Our Reference: SYD20/01395/04
DPIE Reference: SSD-11429726

**EXHIBITION OF ENVIRONMENTAL IMPACT STATEMENT
EDEN STREET MIXED USE REDEVELOPMENT (SSD-11429726)
26-42 EDEN STREET AND 161-179 PRINCES HIGHWAY, ARNCLIFFE**

TfNSW has reviewed the EIS and provides the following advisory comments for the Department's consideration in **TAB A**.

01 EXISTING ROAD SECTION  
1:50

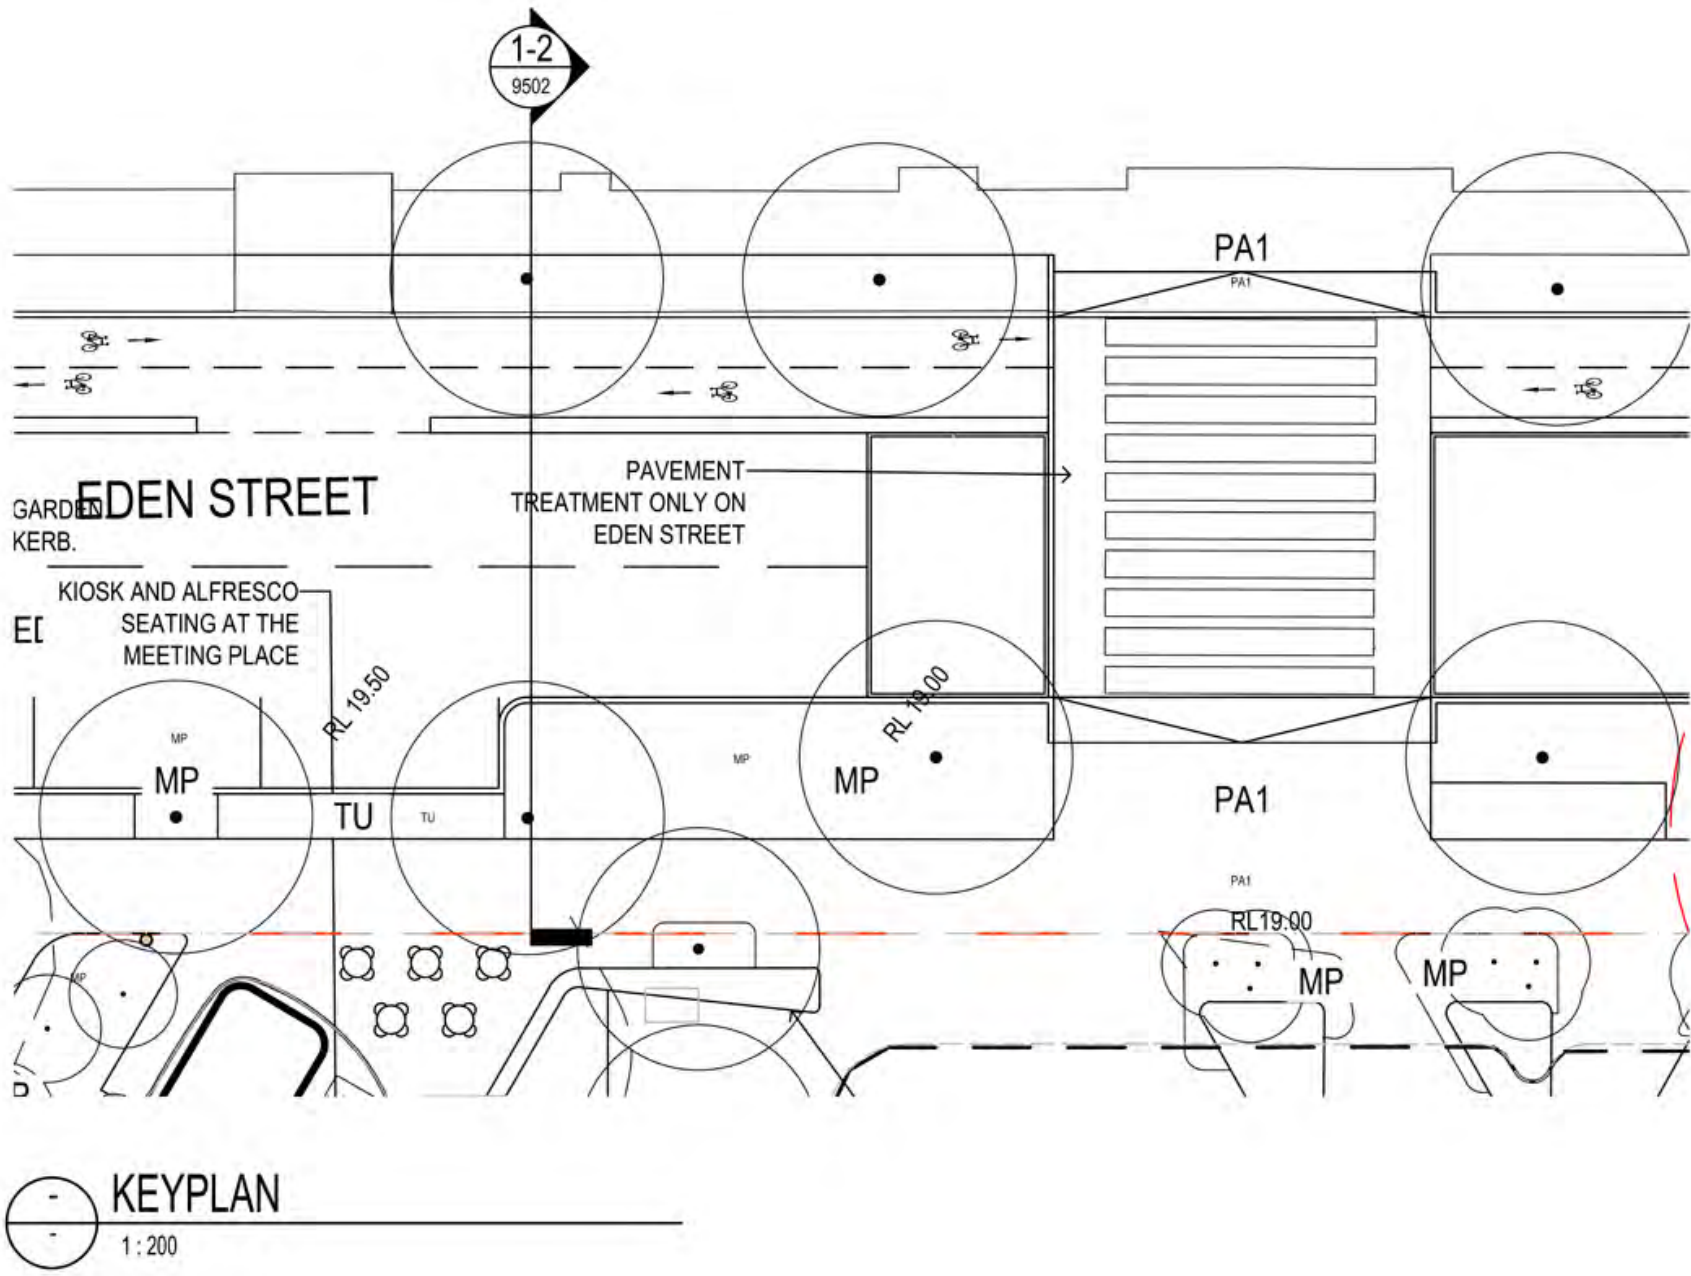
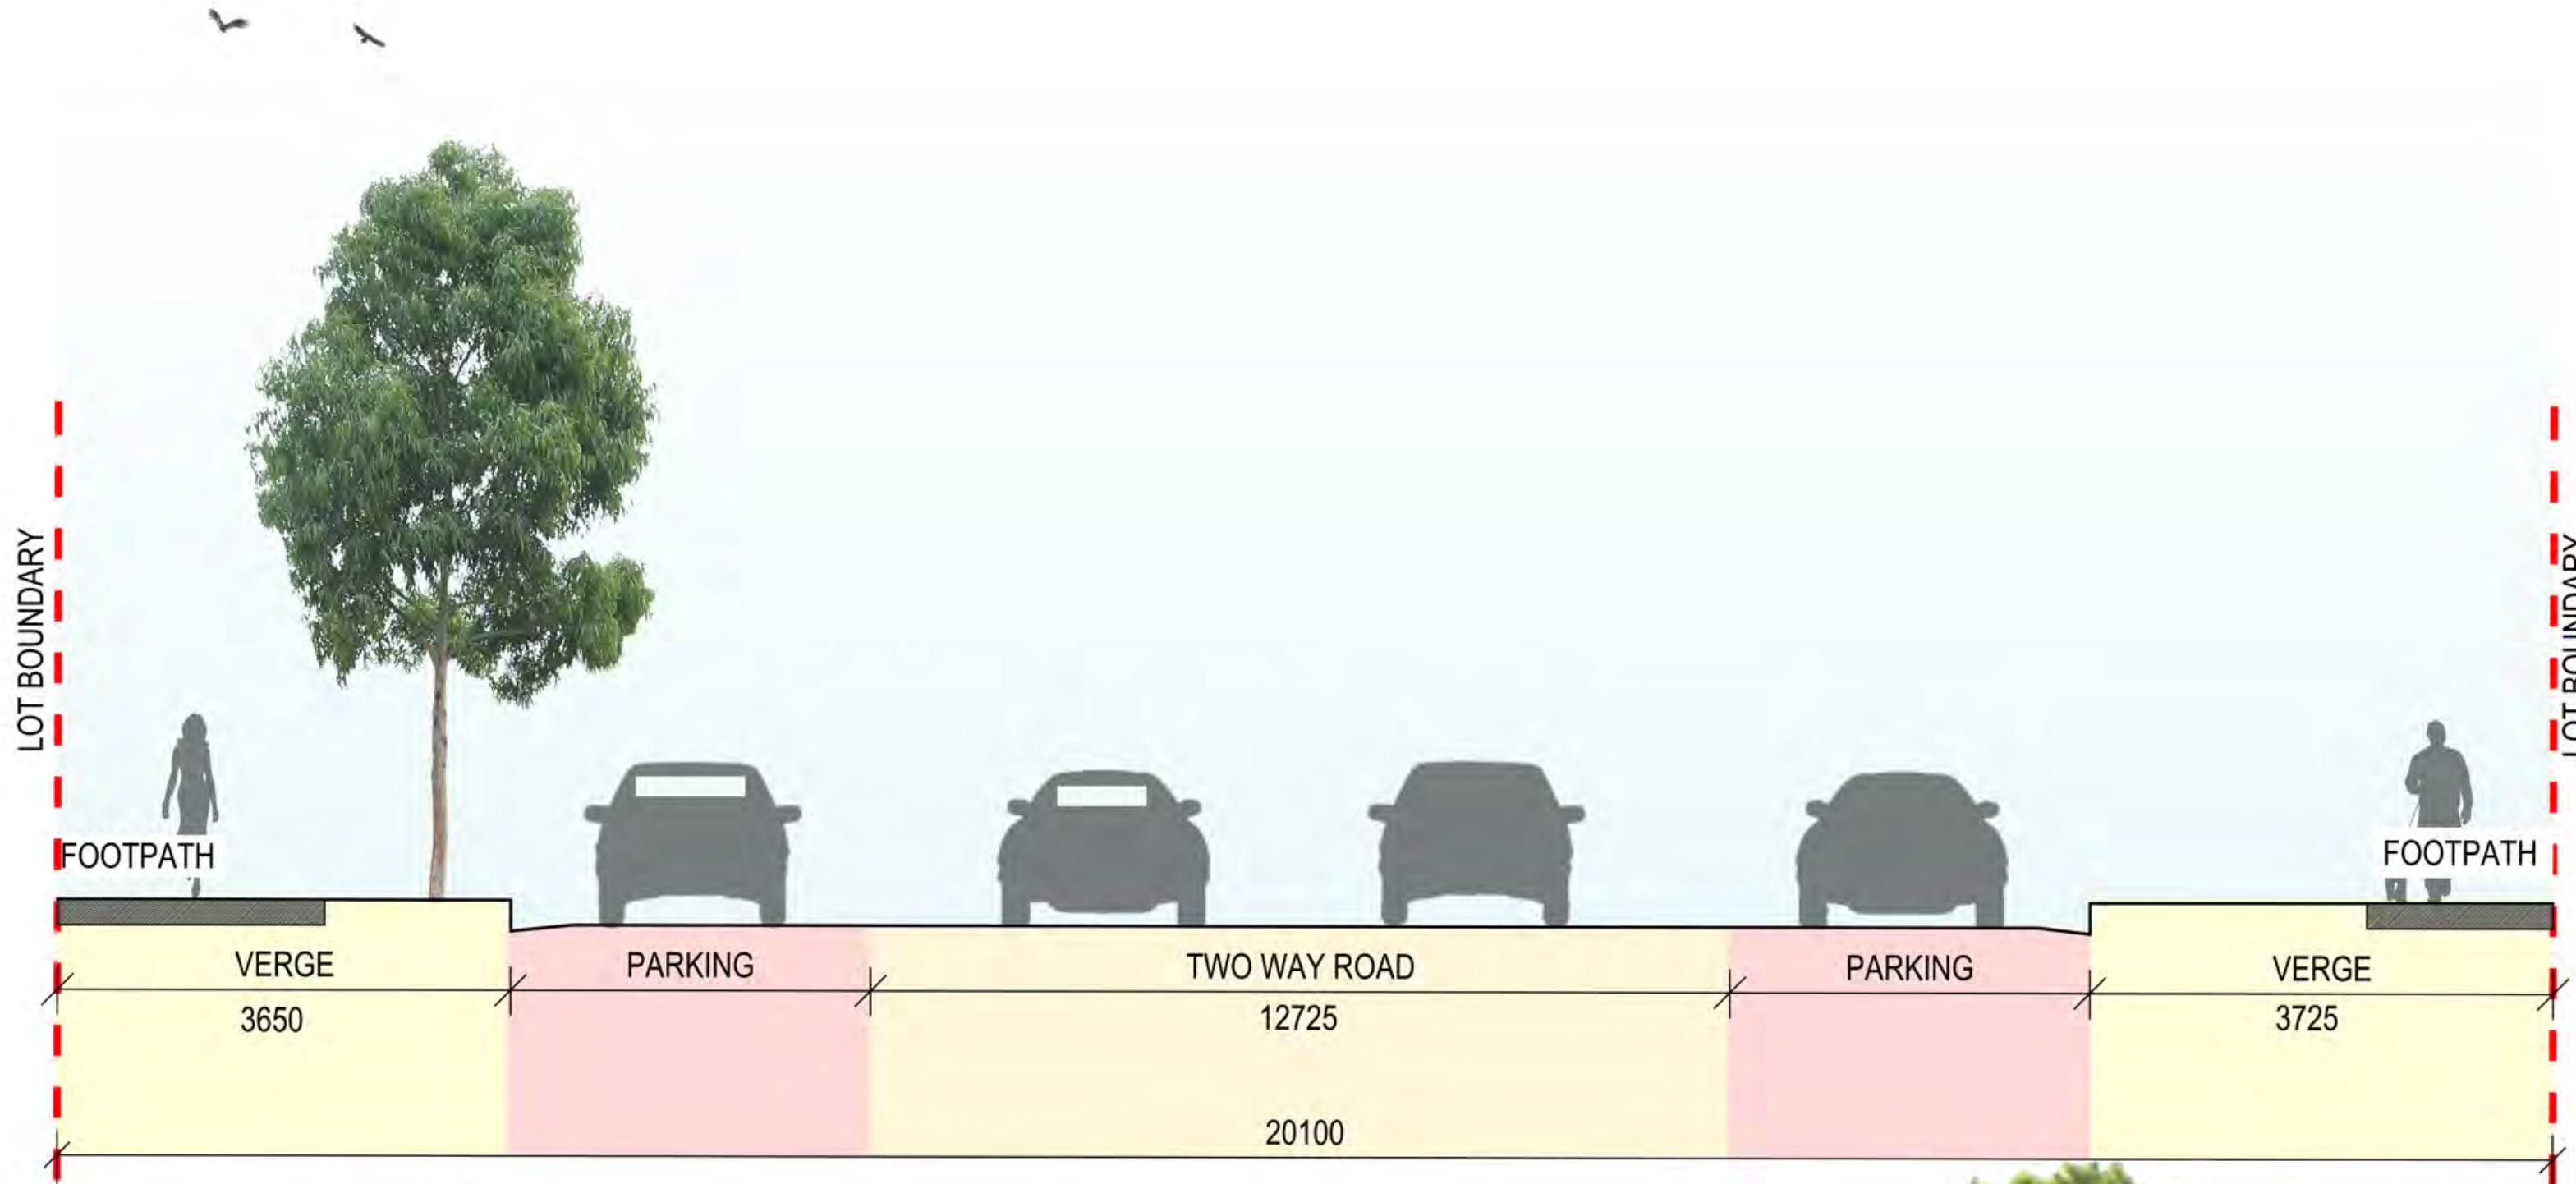
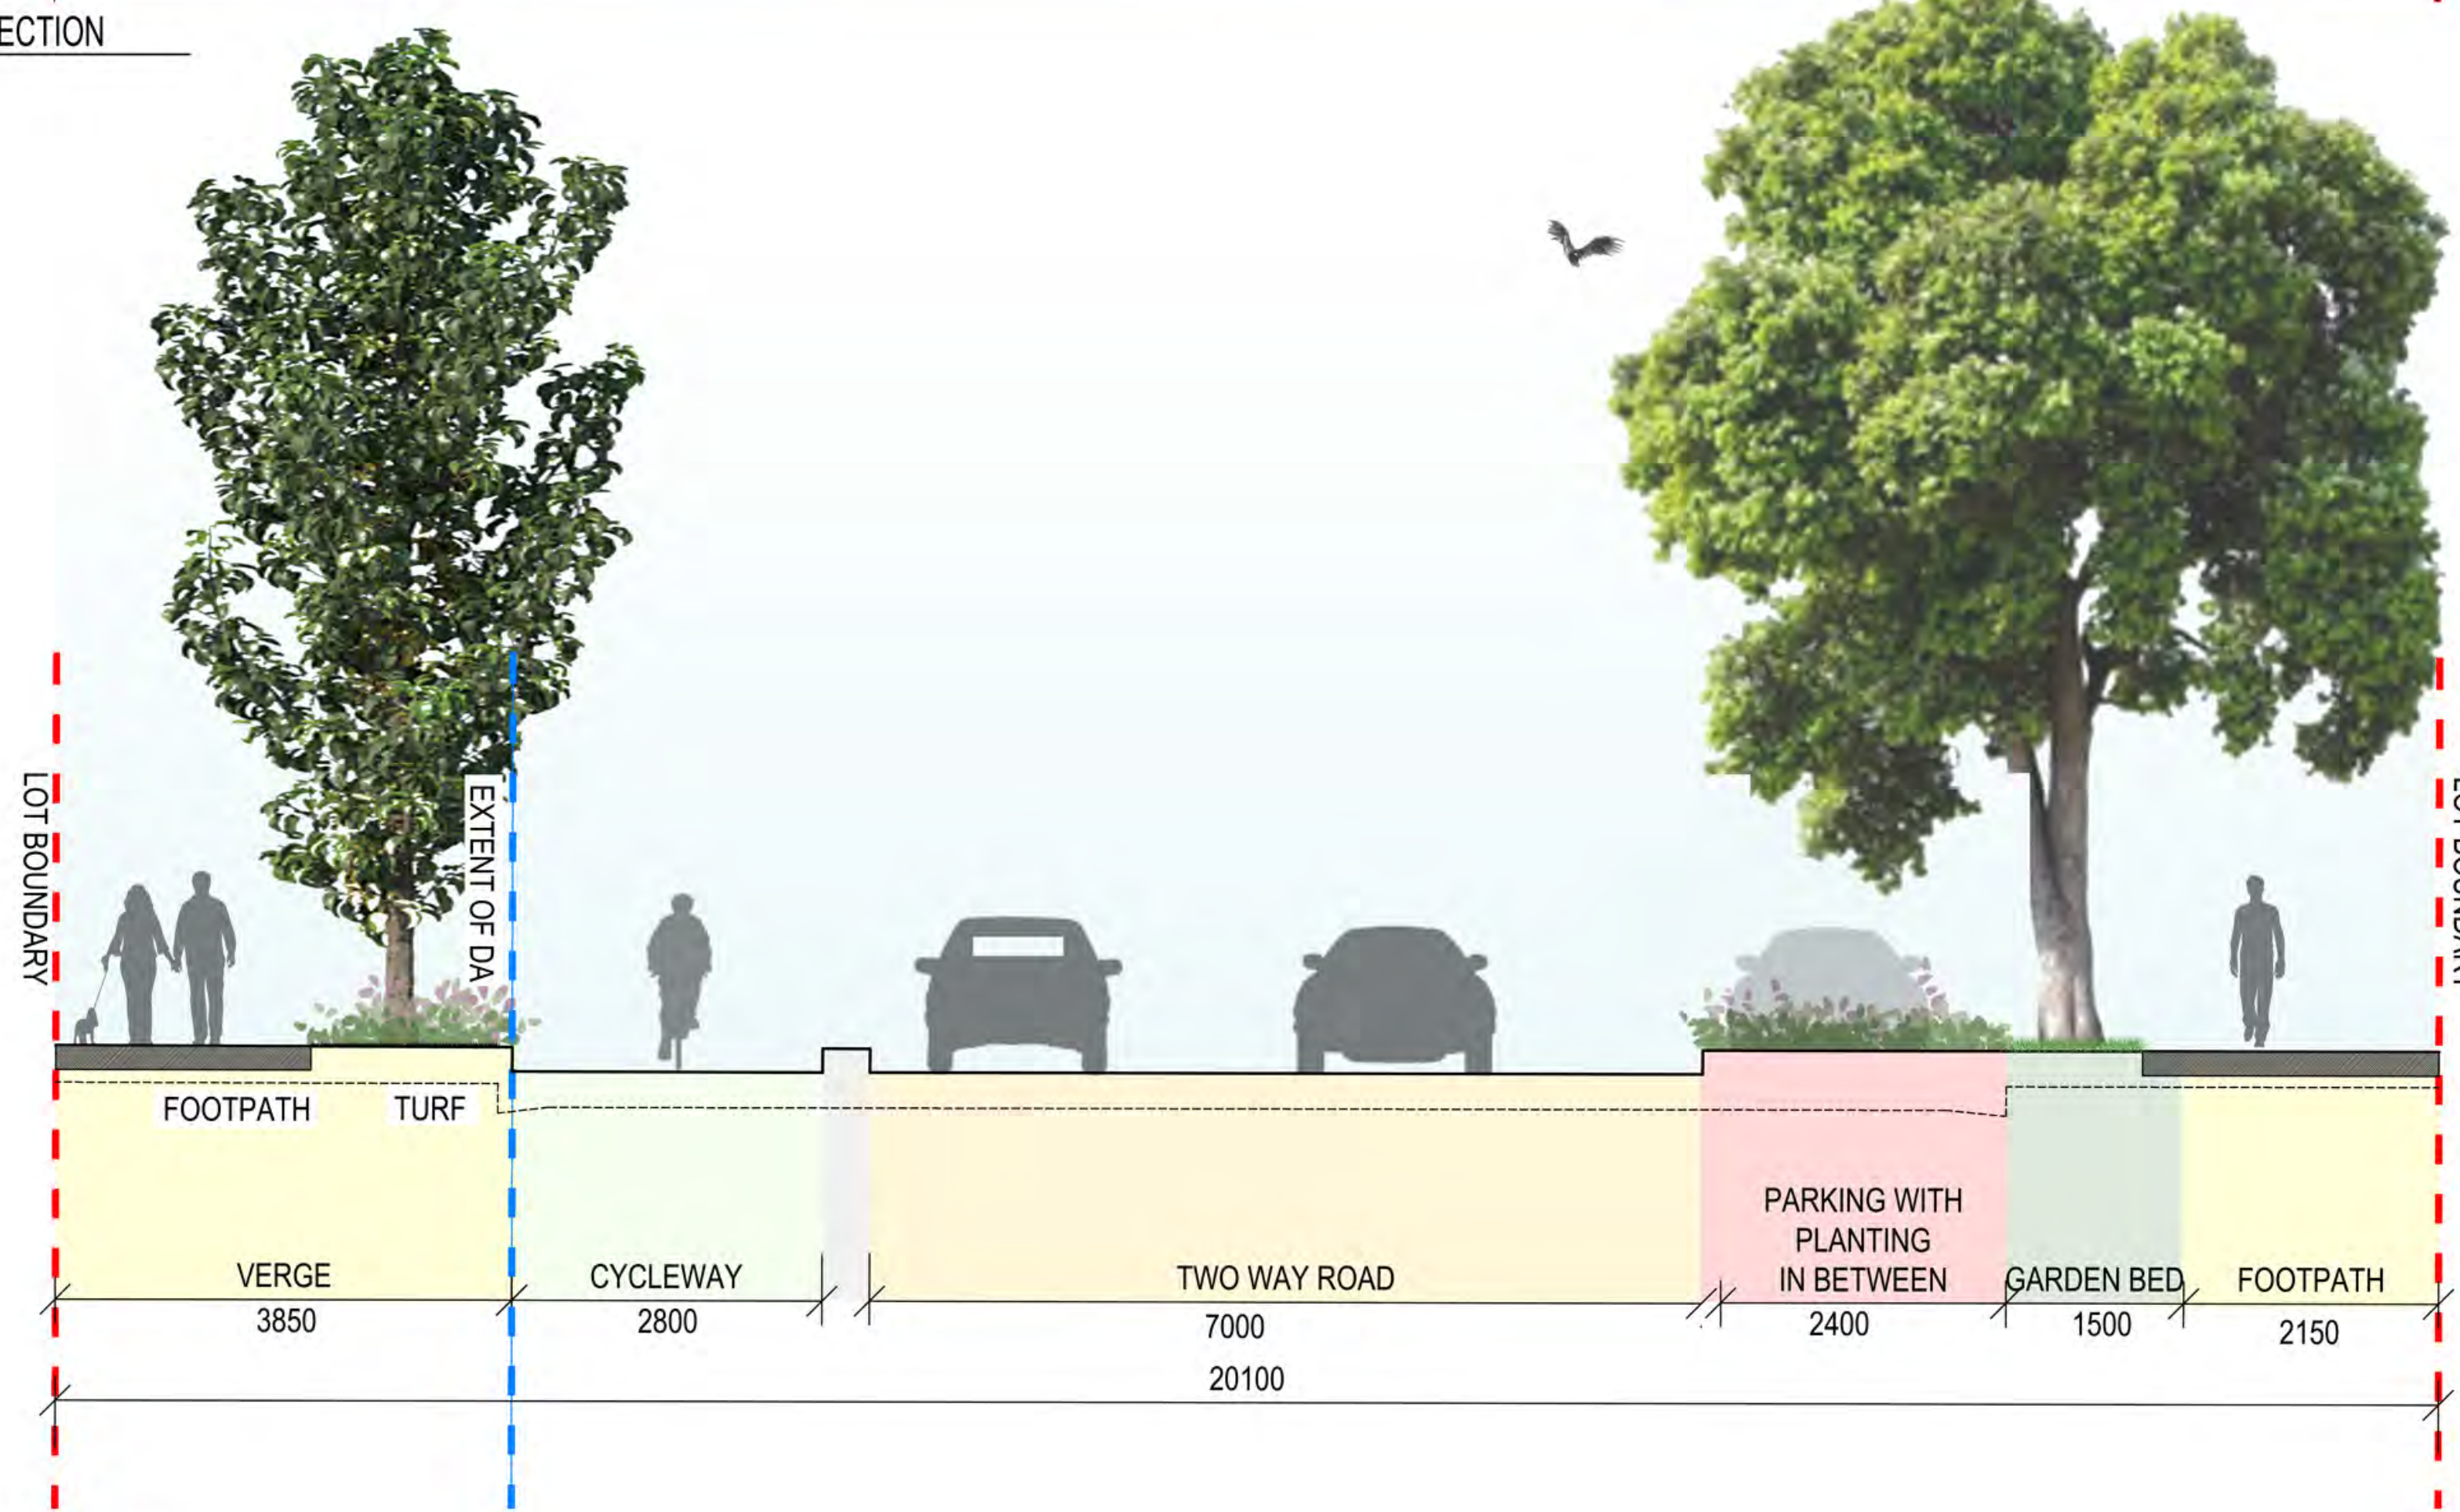
TfNSW supports the proposed upgrades to the surrounding footways of the proposed development on the local road network to improve pedestrian and cyclist connectivity to the Arncliffe Transport Interchange.

The developed options should be discussed with Council and TfNSW.
